Land fronting, Turnbull Road, Fradley, Lichfield

**Application by Massey Limited for the variation of Condition 2 of planning permission
REF: 18/O1693/FUL**

This Application is for variation of Condition 2 of planning permission 18/O169/FUL, 28th October 2020. That planning permission is for the erection of 8no. dwellings and associated works.

DRAWING TITLE
PLANNING | HOUSE TYPE 5

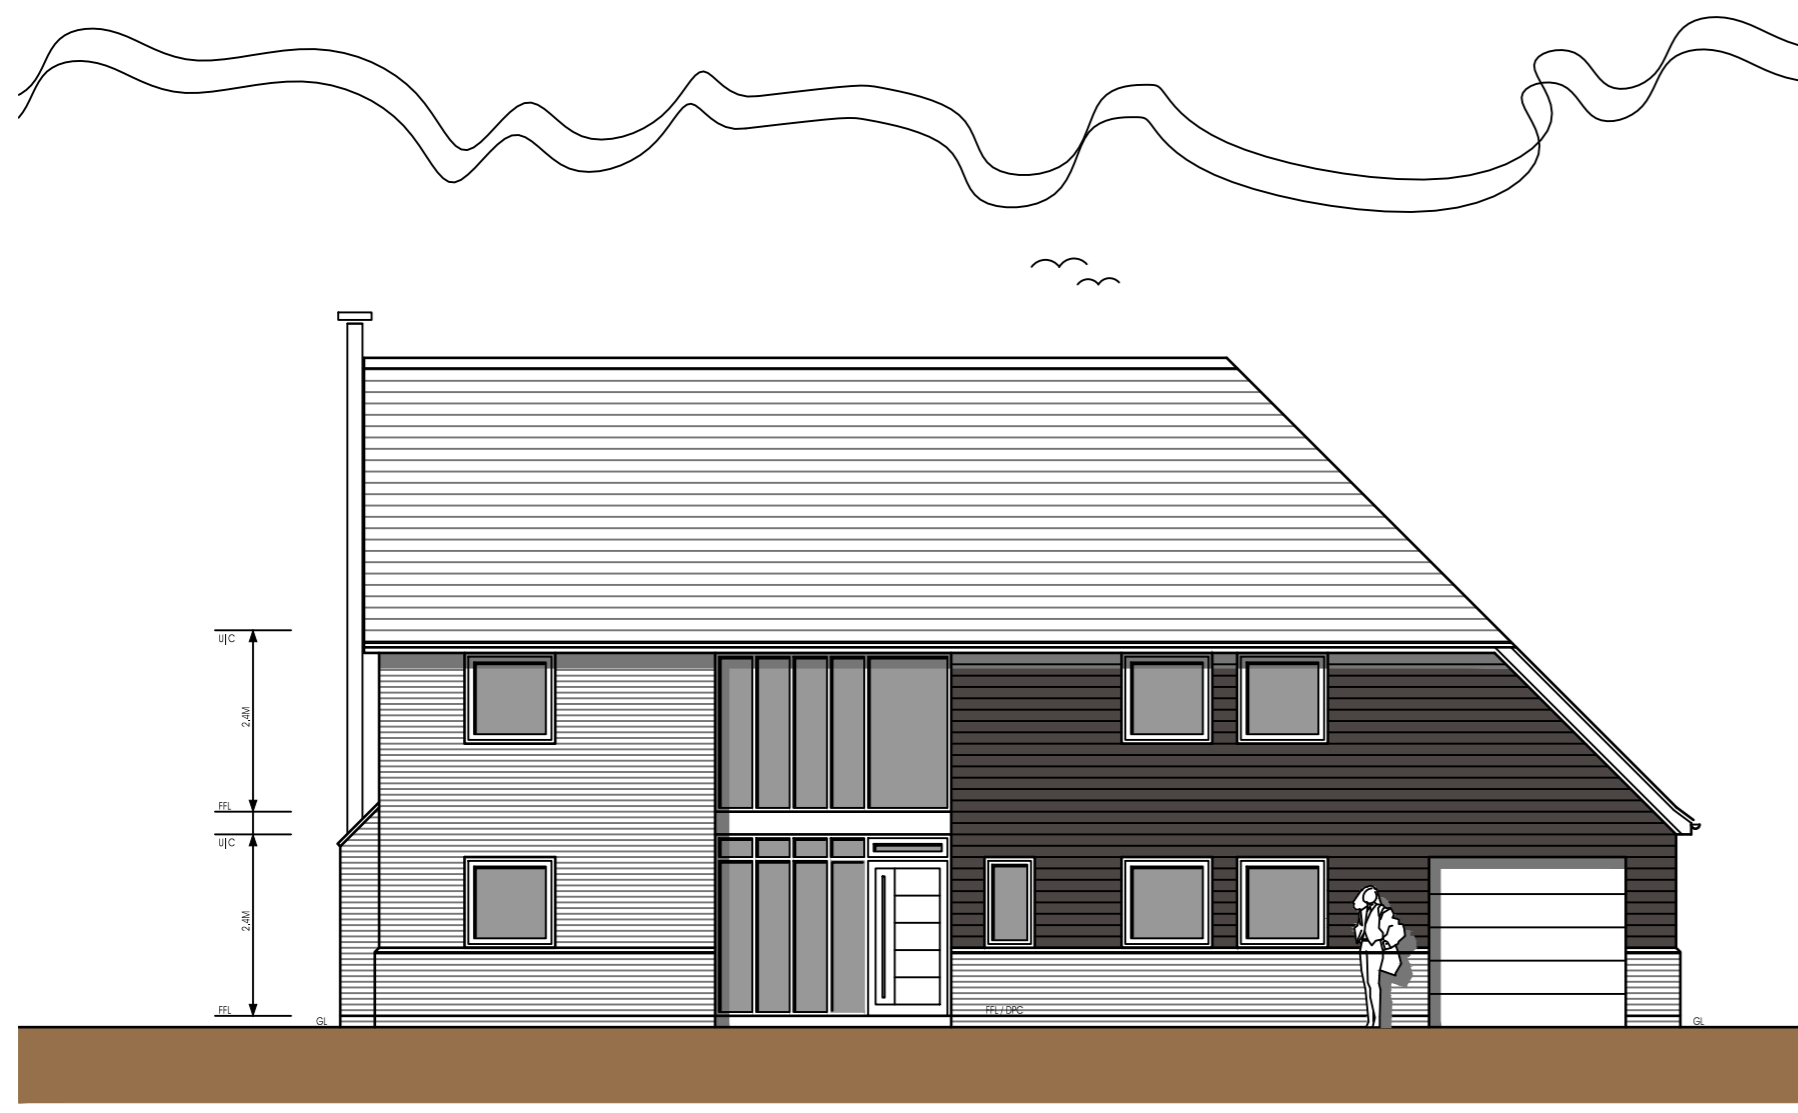
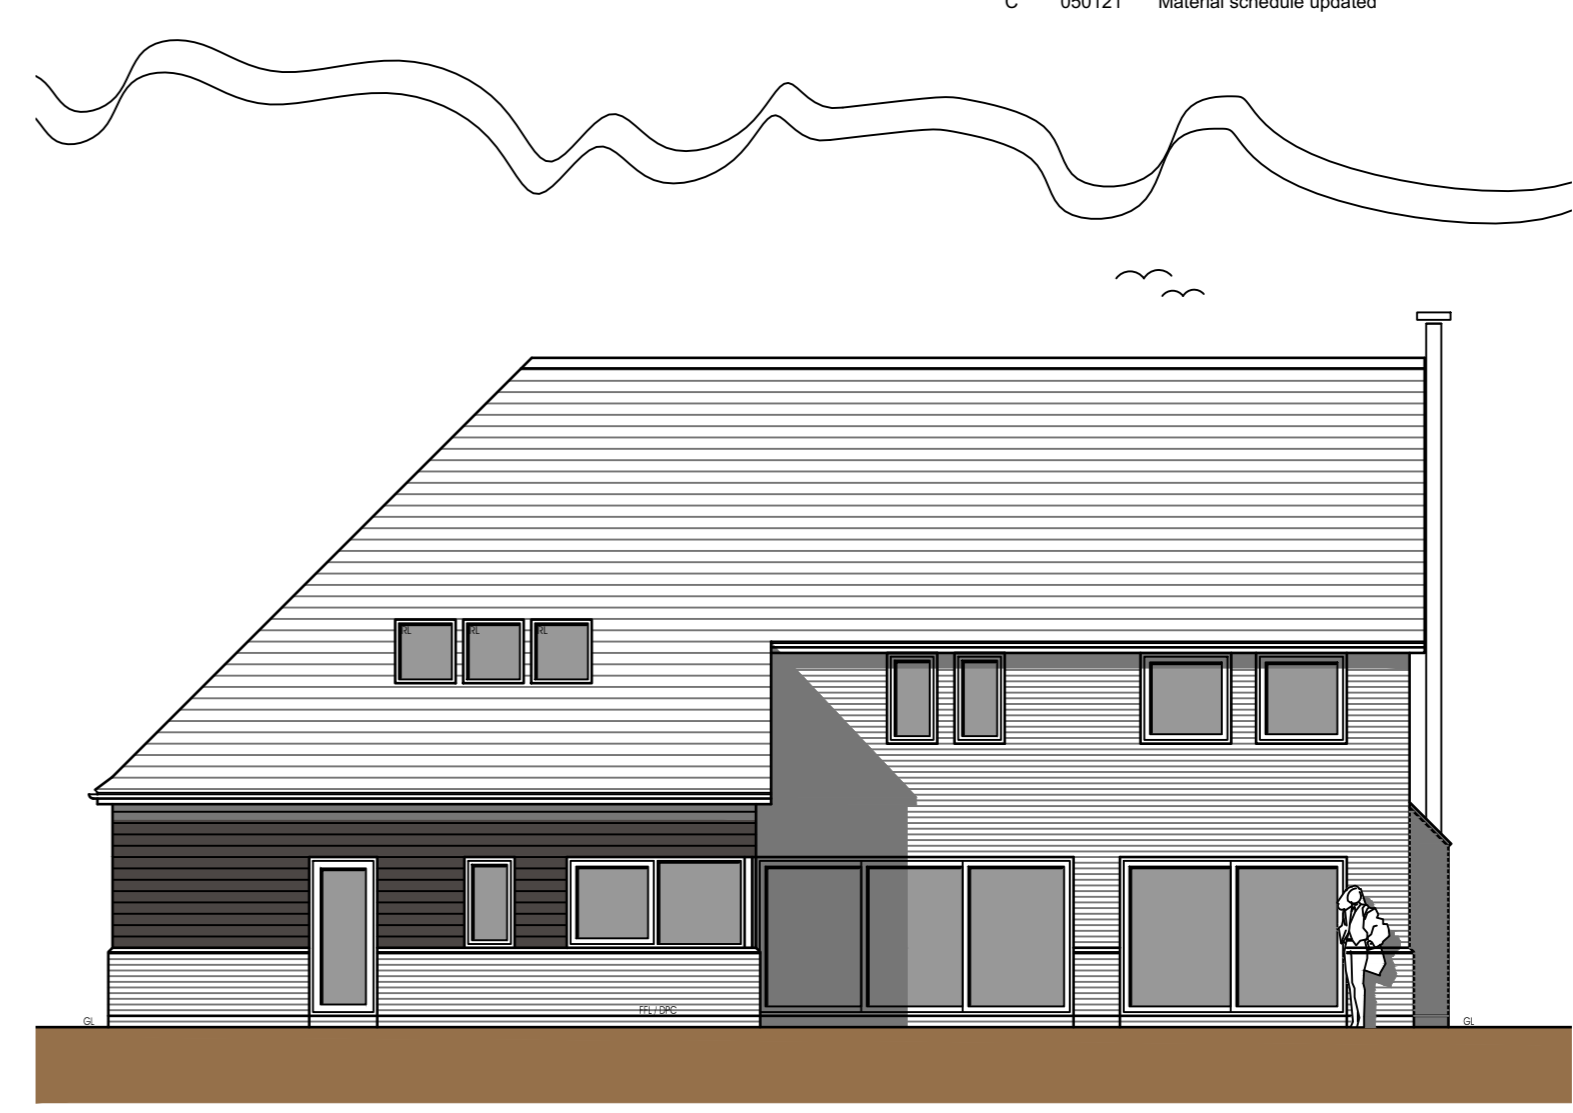
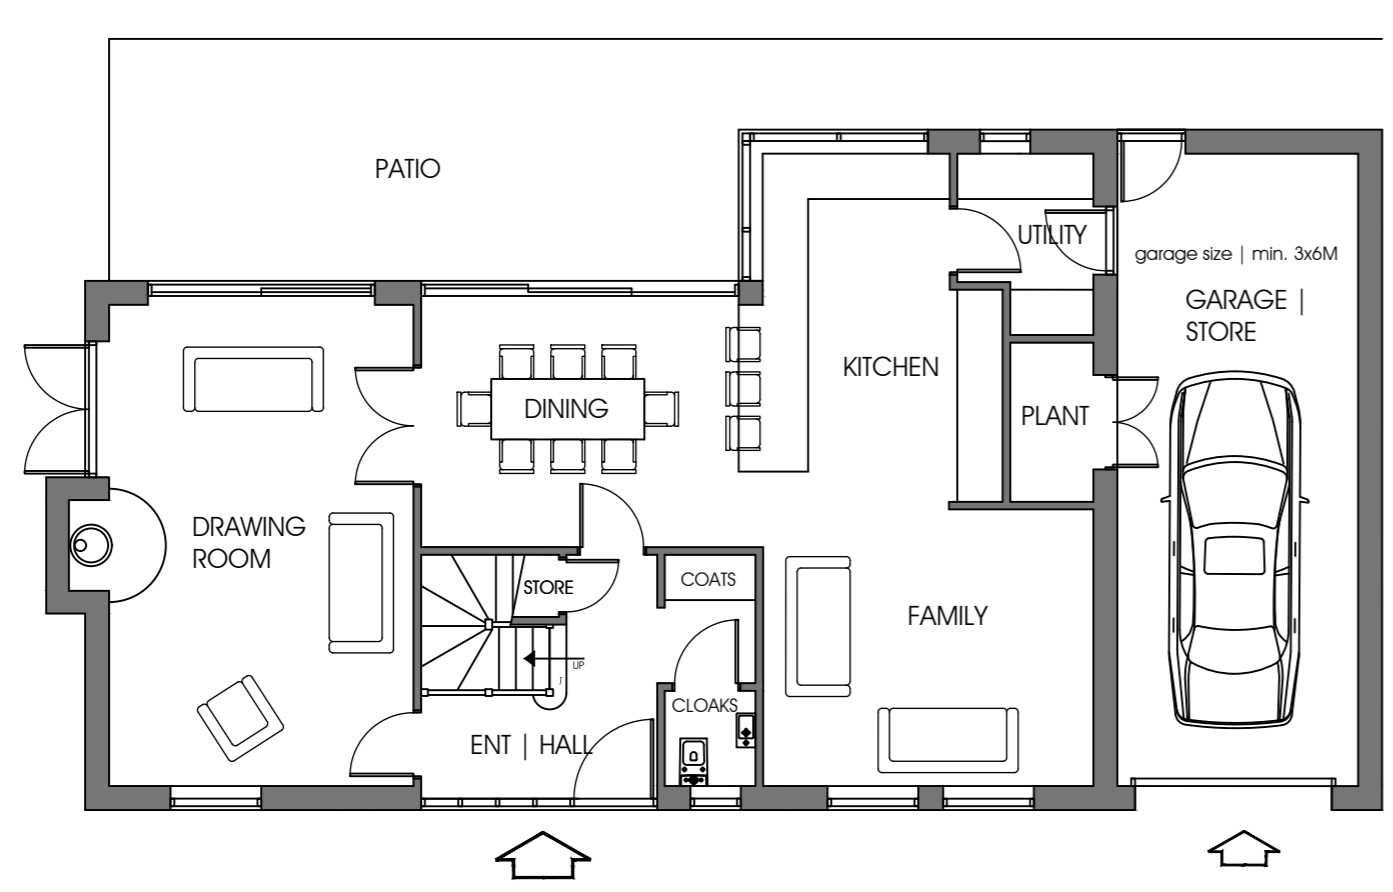
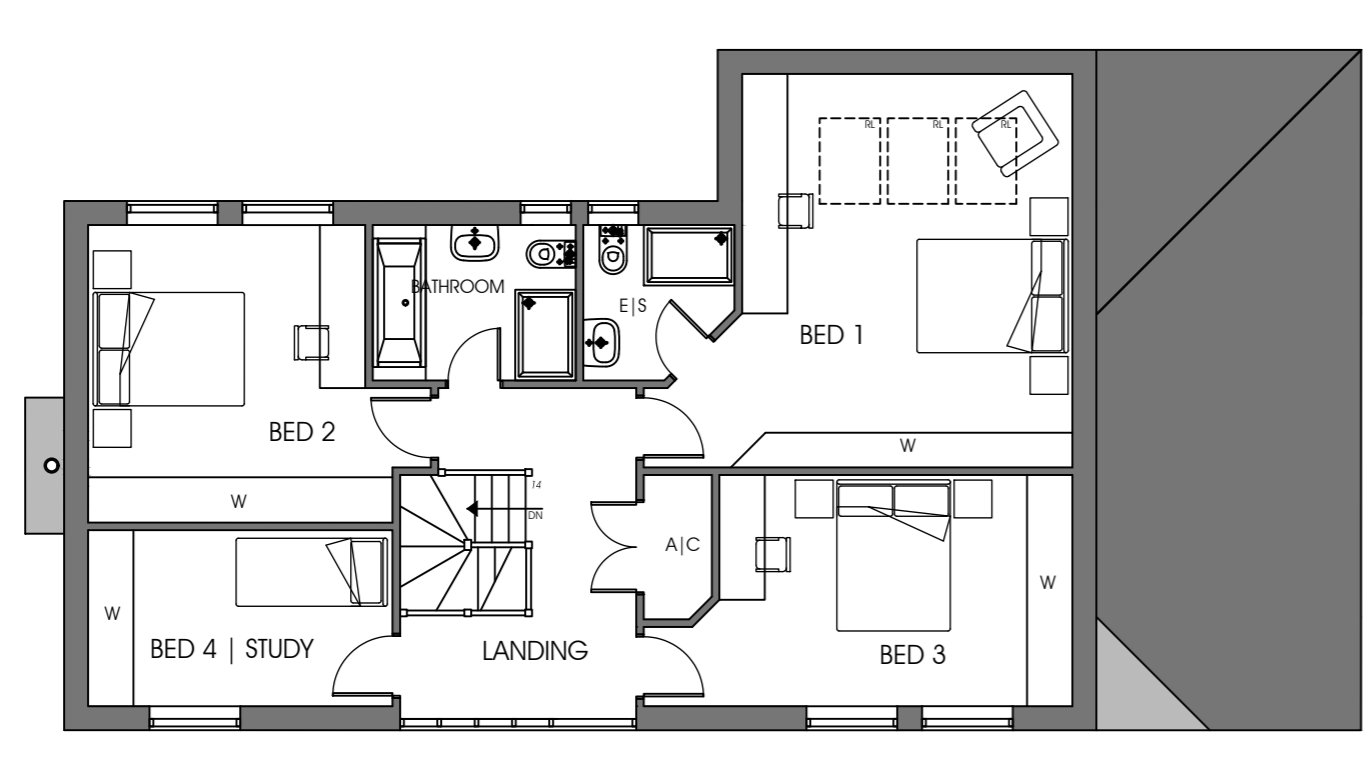
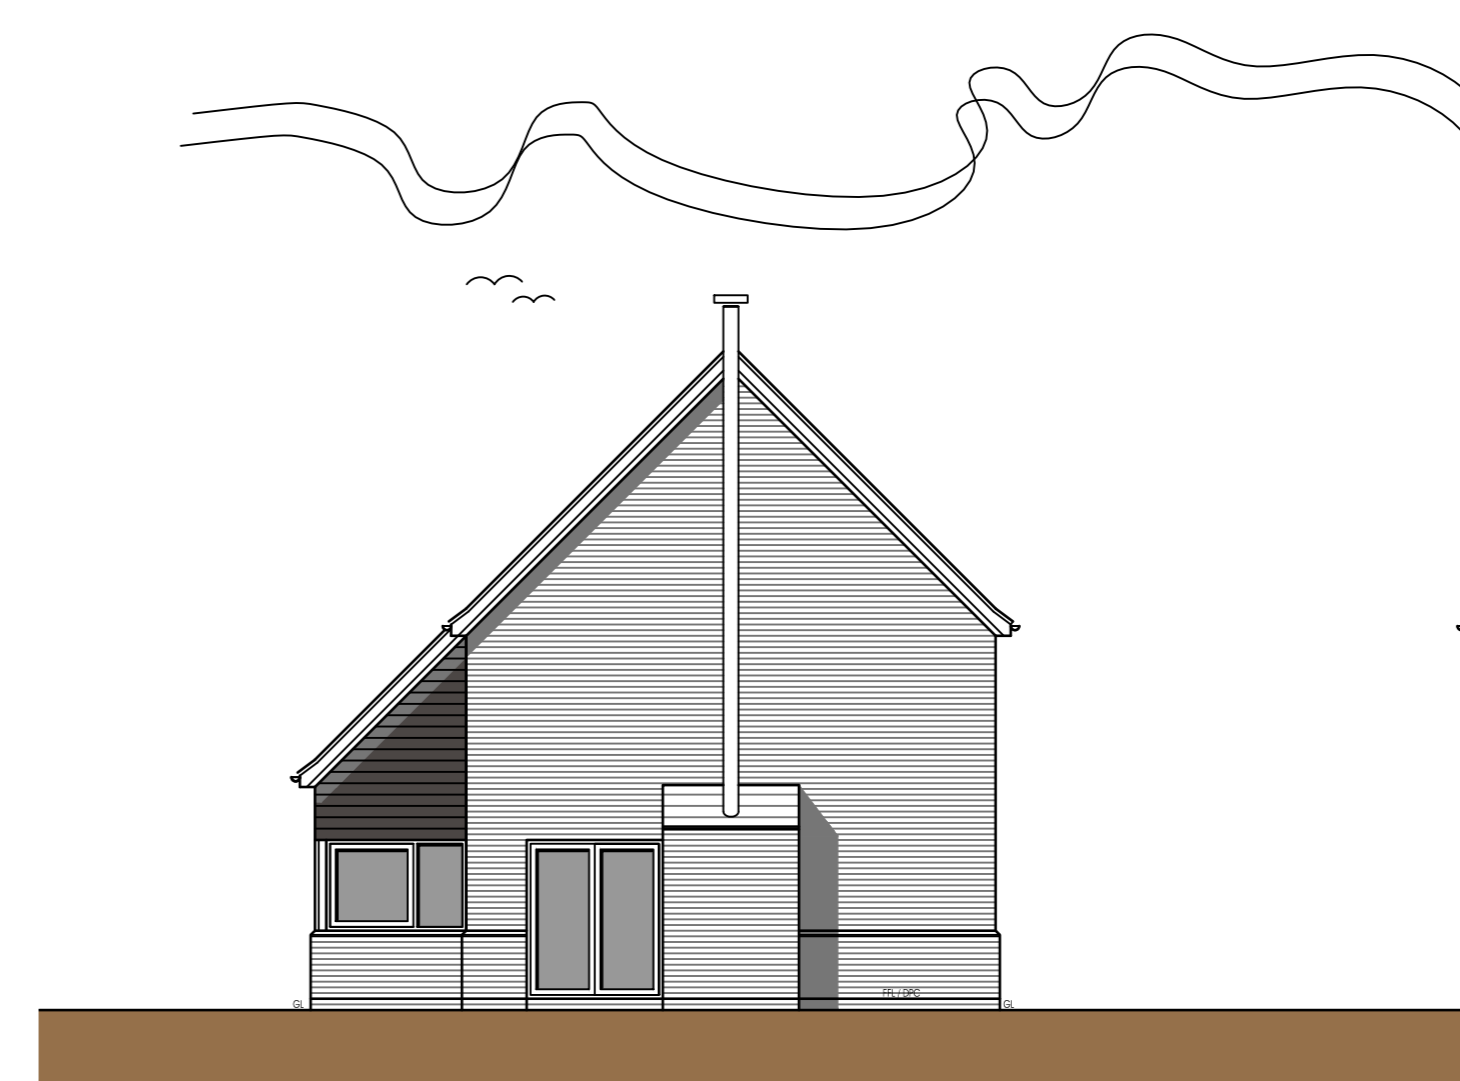
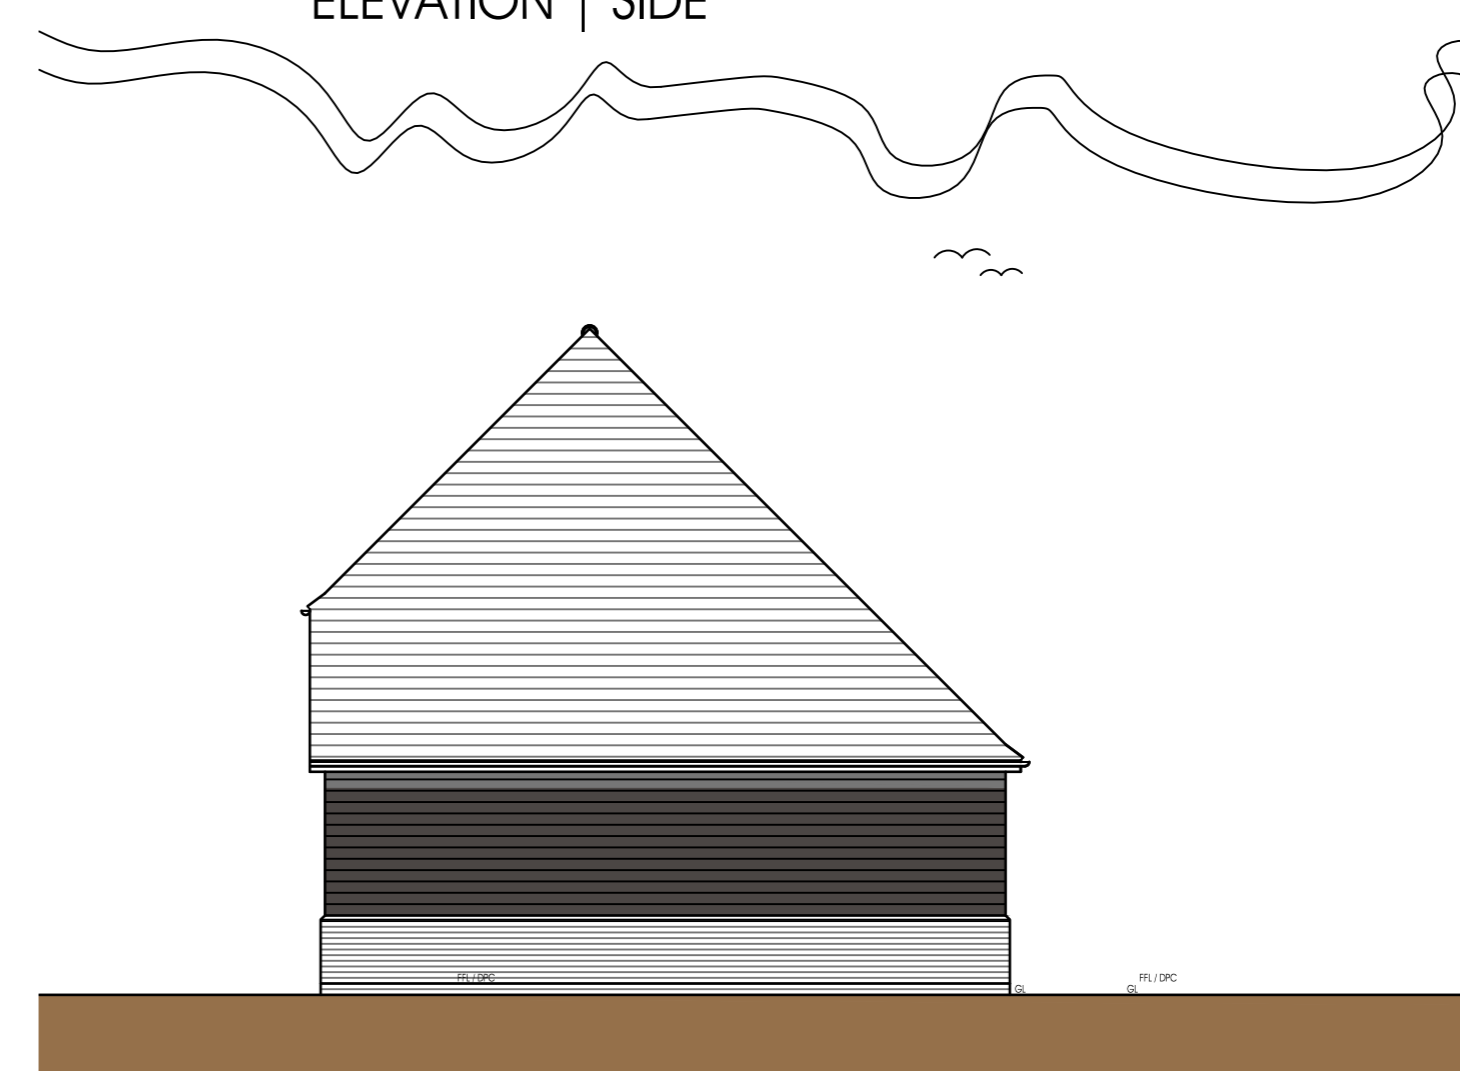
Proposed minor alterations to external materials, namely the roof covering and window frames are outlined below.

Roof covering - Marley Ferndale tiles do not exist. Marley Edgemere tiles are a slate-style tile, in keeping with the consented design.

Windows and doors - Flush casement anthracite grey window frames proposed in lieu of PPC black frames.
